The proposed East Pye Solar scheme is made up of disconnected parcels of land stretching over a swathe of South Norfolk. It was clear during the Open Hearings at Dunston Hall that East Pye Solar's site selection was opportunistic at best with little justification for much of the sites 'selection other than willing landowners coming forward for financial gain. Taken as individual sites there is no doubt that planning consent would be refused but by lumping the sites together connected by kilometres of cabling the Applicant is effectively circumventing local planning and submitting the scheme as an NSIP thereby seeking a Development Consent Order which will be decided by the Secretary of State for Energy and Net Zero.

Figure 11.6: Likely and Suitable Routes to the Scheme
 Sites 7, 8 and 9
 Revision A

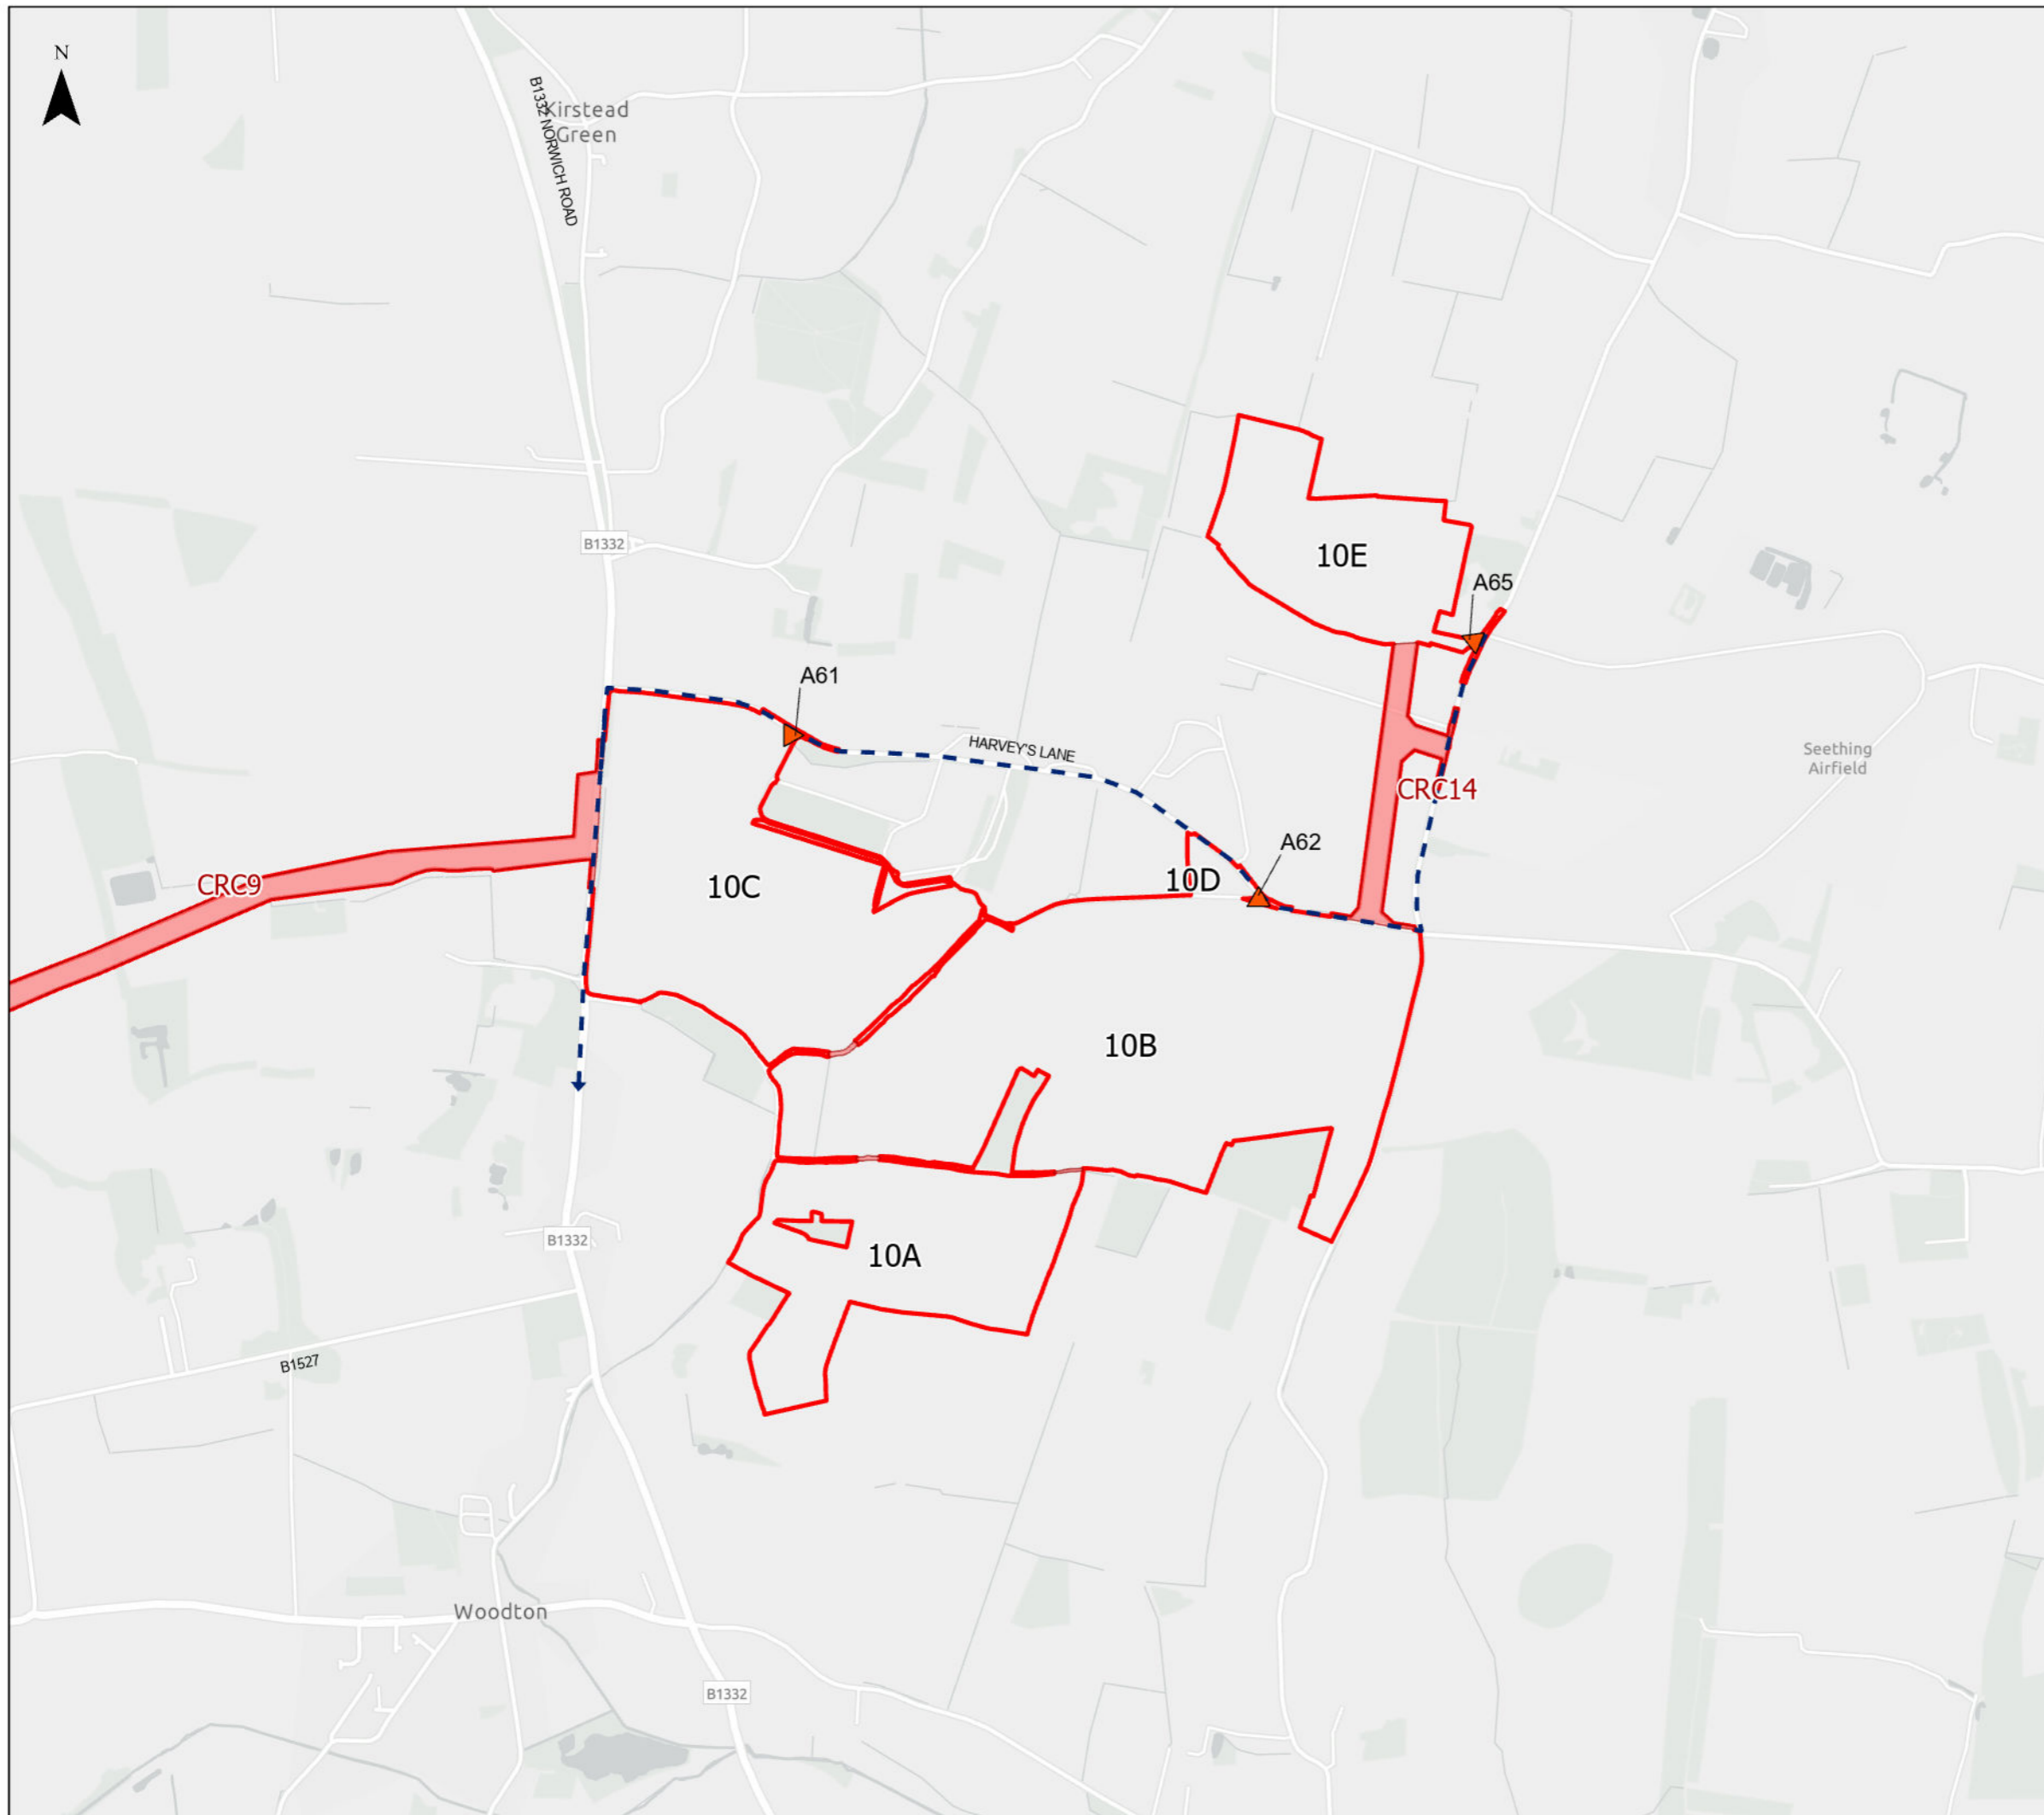
The Applicant's Outline Construction Traffic Management Plan document APP/7.6 identifies access point A50 on Market Lane. Market Lane is a quiet, single track roadway and the access point A50 is where the road crosses a culvert over a stream tributary of the river Tas. This part of the road and adjoining fields is prone to flooding after prolonged or

heavy rain situated as it is at the lowest point of the surrounding sloping fields occupied by sites 8A and 8B which naturally drain down to accumulate water at this point. The photograph included here was taken on Market Lane at the location of access point A50 looking south east with site 8B to the left of the trees and site 8A to the right illustrates this. The road and adjoining fields are submerged under up to two feet of water. Placement of solar panels across sites 8A and 8B would have the effect of increasing the speed of rainwater runoff and only augment the flooding situation along this stretch of road. No proposals for flood mitigation in this location are provided in the Applicant's documentation.

Figure 30. Site 8 showing Grade II Listed Buildings, Conservation Areas and Non-Designated Heritage Assets

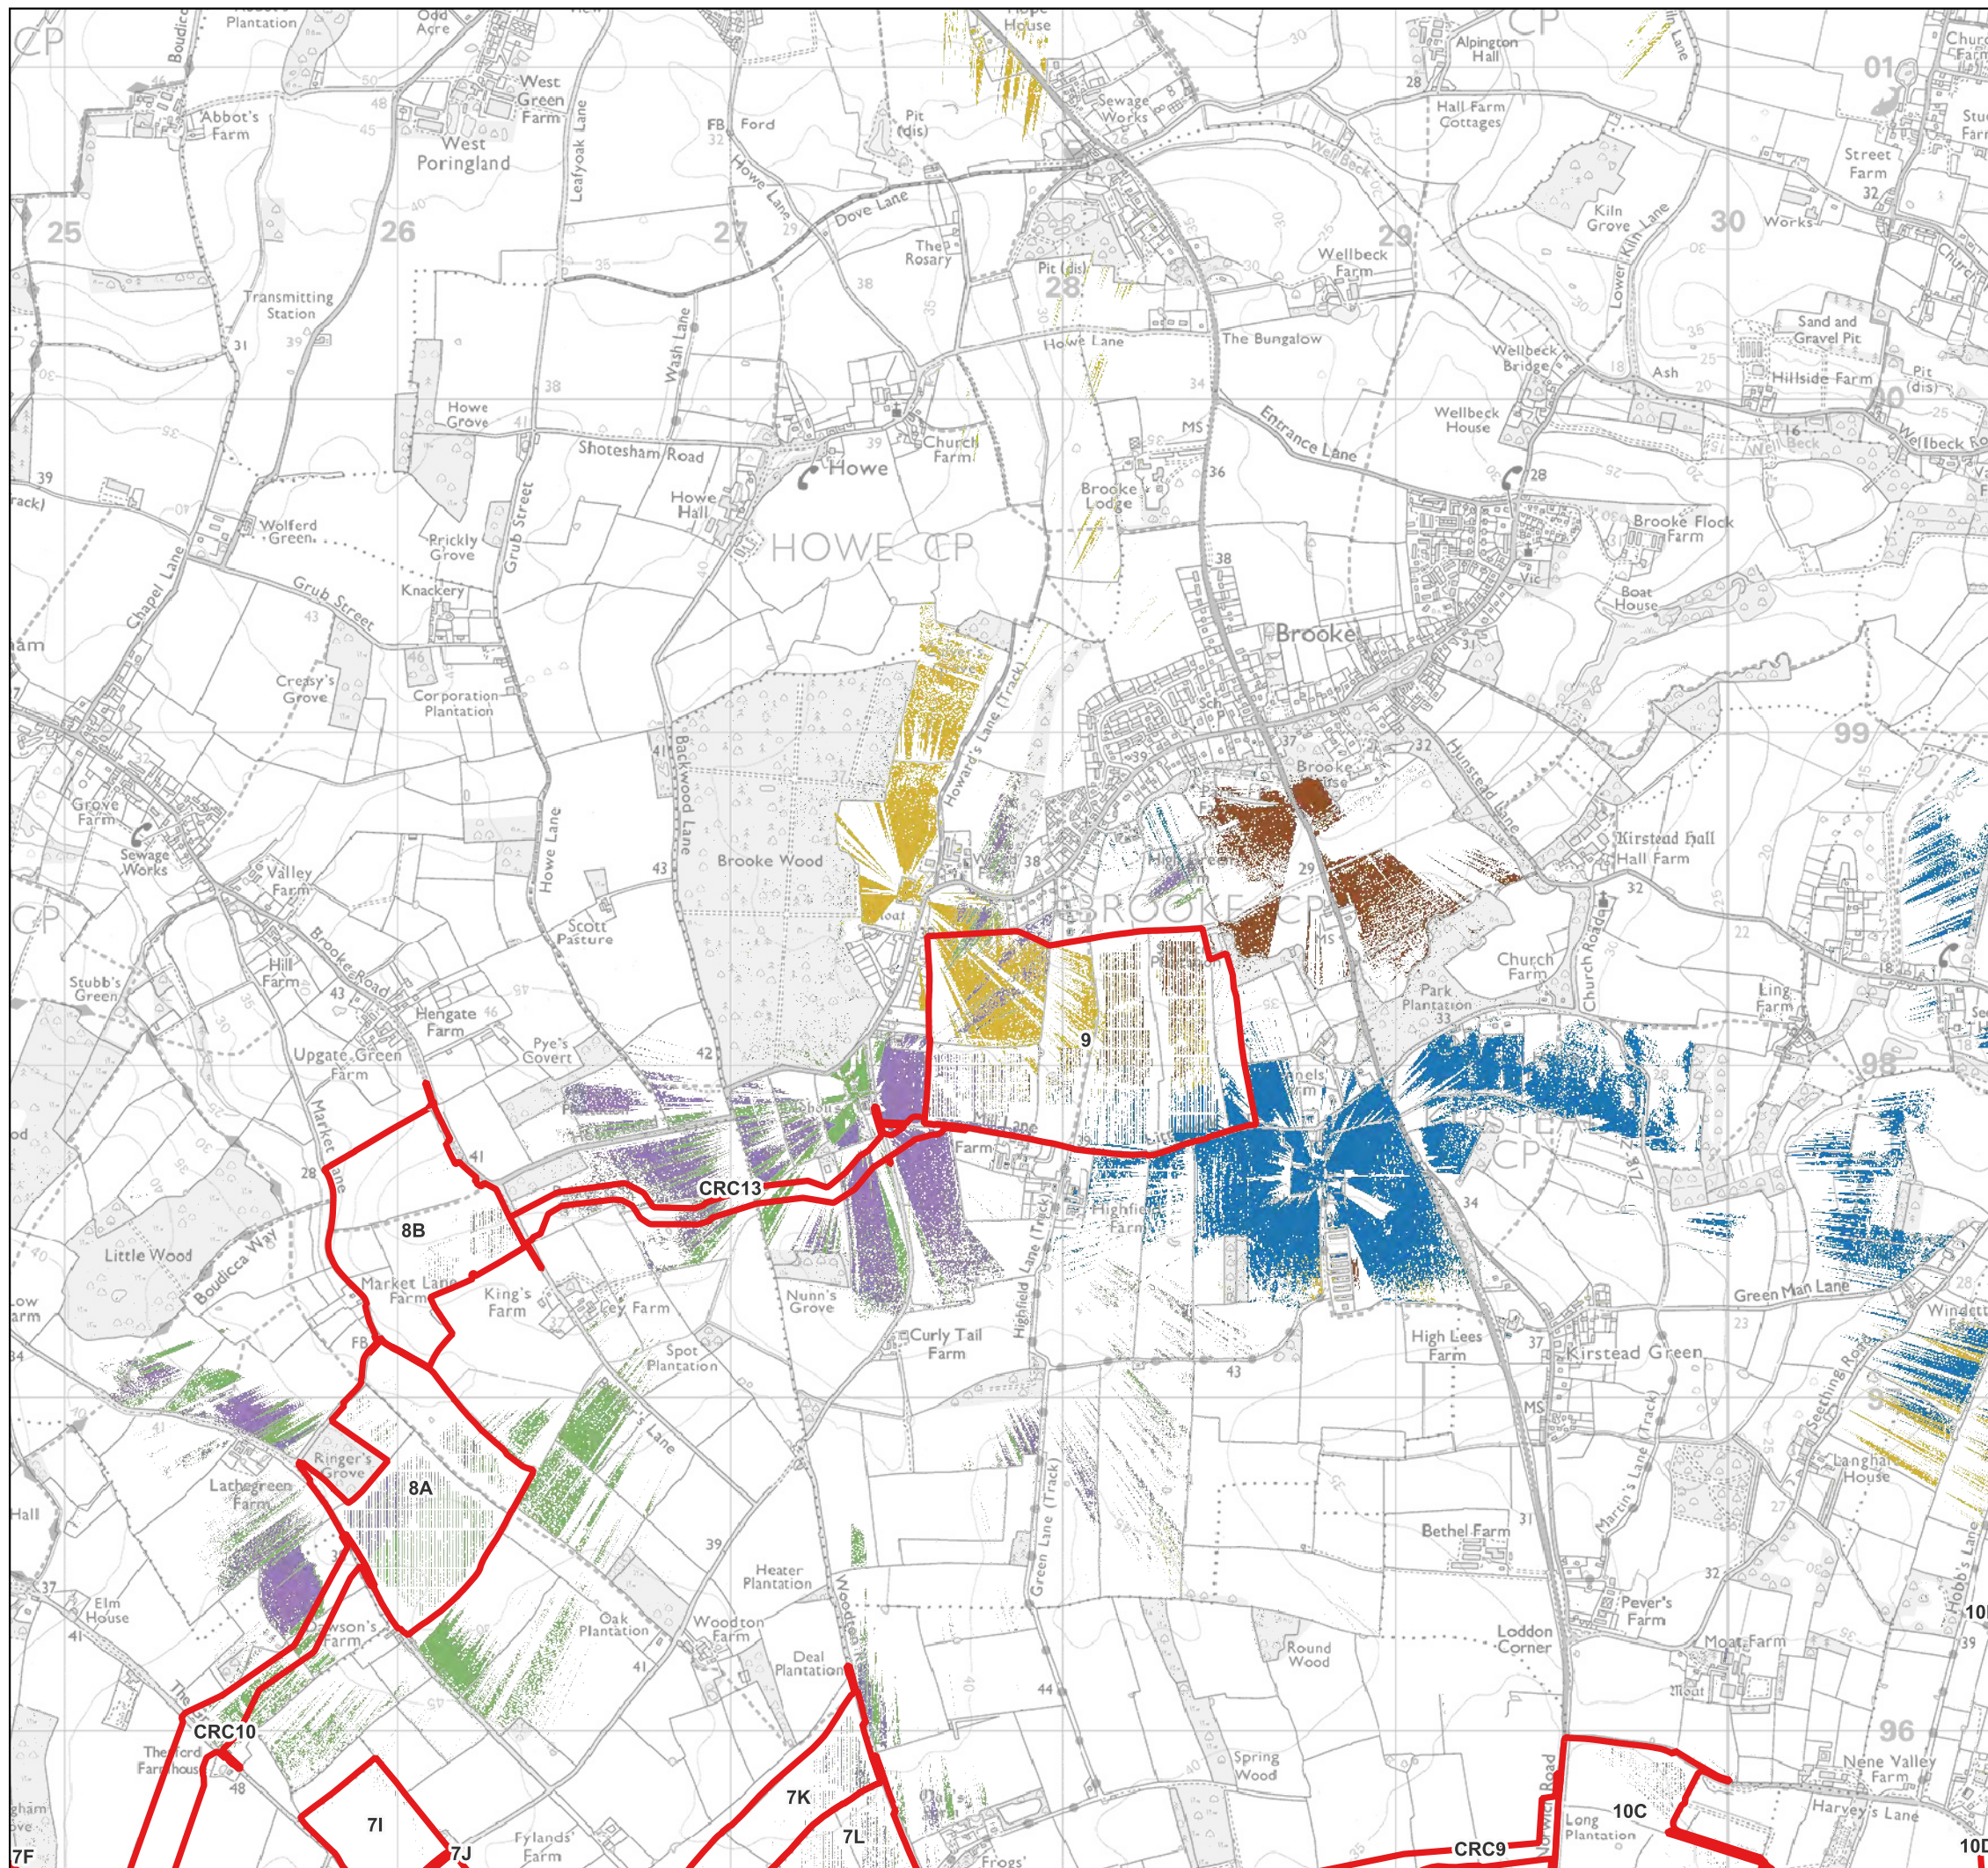
My home in Shotesham overlooks Site 8. An independent Landscape Architect has judged that Site 8 is part of a valued heritage landscape and that the harm of the proposed scheme and its impacts on the setting of the Shotesham Conservation Area would be significant. Every day I walk with my dog down onto Market Lane from where I access the local footpaths, typically Shotesham FP19, FP17 or FP22. The East Pye scheme would destroy the enjoyment and appreciation of this rural landscape. Rather than being immersed in the variations of the changing seasons and the farming cycle, I and the numerous other users of these PRow would be faced with glass and steel. It is proposed in the Applicant's Article 12 that FP19 and FP22 would be subject to temporary closure disrupting rights of access to all users. Notably there is no definition of 'temporary' in the Applicant's documentation. Ultimately sections of these PRow would be permanently bounded by steel fencing. How this fencing would eventually appear is not represented in the applicants documentation which is a significant omission. Shotesham FP17 forms part of Boudicca Way, an important long distance footpath from Norwich to Diss, which is described in the Long Distance Walkers Association website: "Boudicca Way passes through the beautiful, unspoilt rural countryside of South Norfolk and the Waveney Valley". Sites 8A and 8B are directly seen from the Shotesham FP17 section of Boudicca Way and the proposed solar installation on these sites would have an overwhelming visual effect. Given the elevated viewpoint from Boudicca Way across the gently sloping valley sides occupied by sites 8A and 8B, no amount of mitigation planting or screening will lessen the visual impact of the solar installation and associated structures.
